Department of Primary Industries

10 APR 2014

Glen Innes Wind Farm (MP07_0036 Mod 2) Proposed Modification

APPENDIX 2 PROJECT LAYOUT

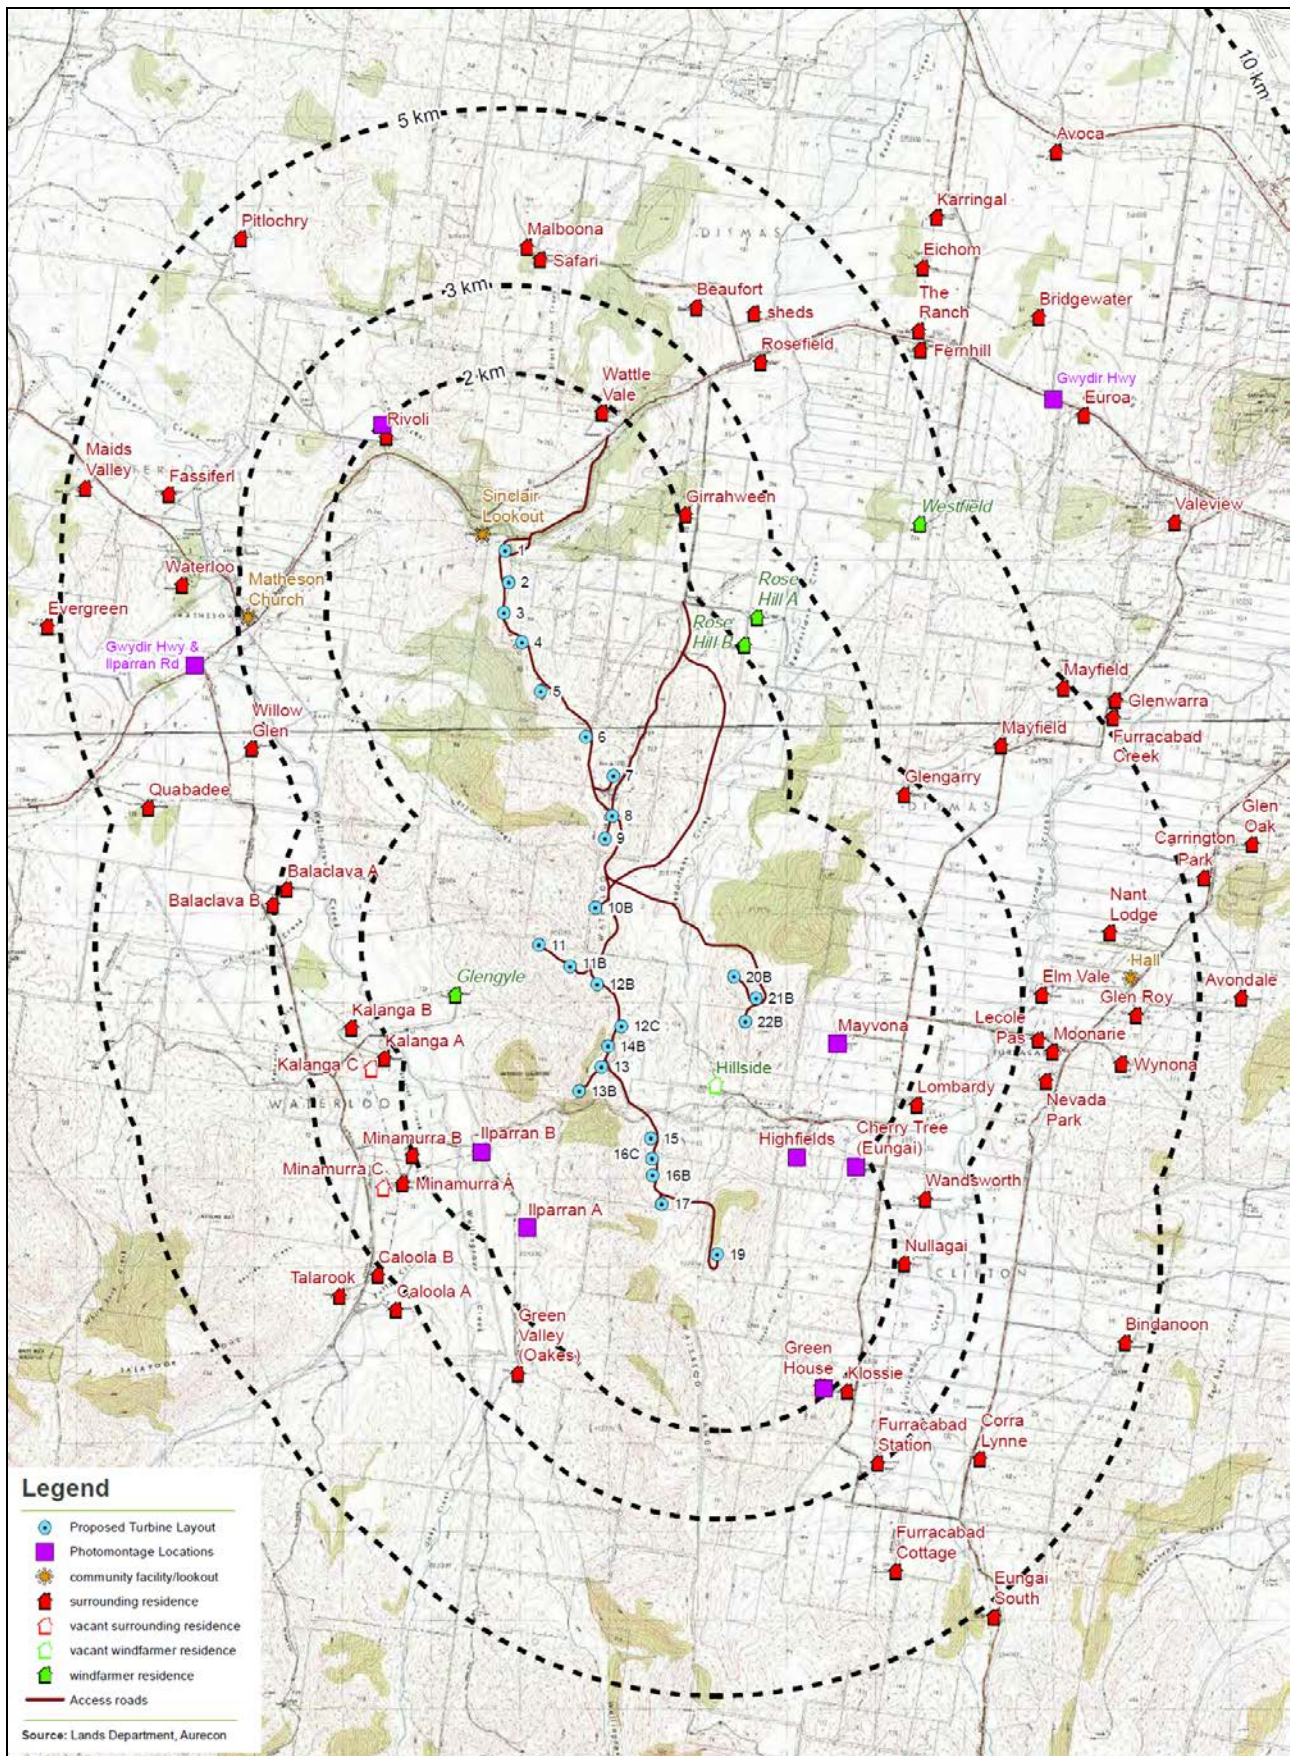
The relocation of these two towers does not appear to impact on any Crown lands, however the relocation of tower 13 combined with an increase in blade size, and increased blade size of tower 14B brings their reach very close (if not right up to) a crown road. At the northern end of the proposed wind farm, the increase in blade diameter may put the blades over a section of untenured crown road.

Crown Lands advise that the proposed changes will require clarification from the proponent regarding any impact to these Crown roads.
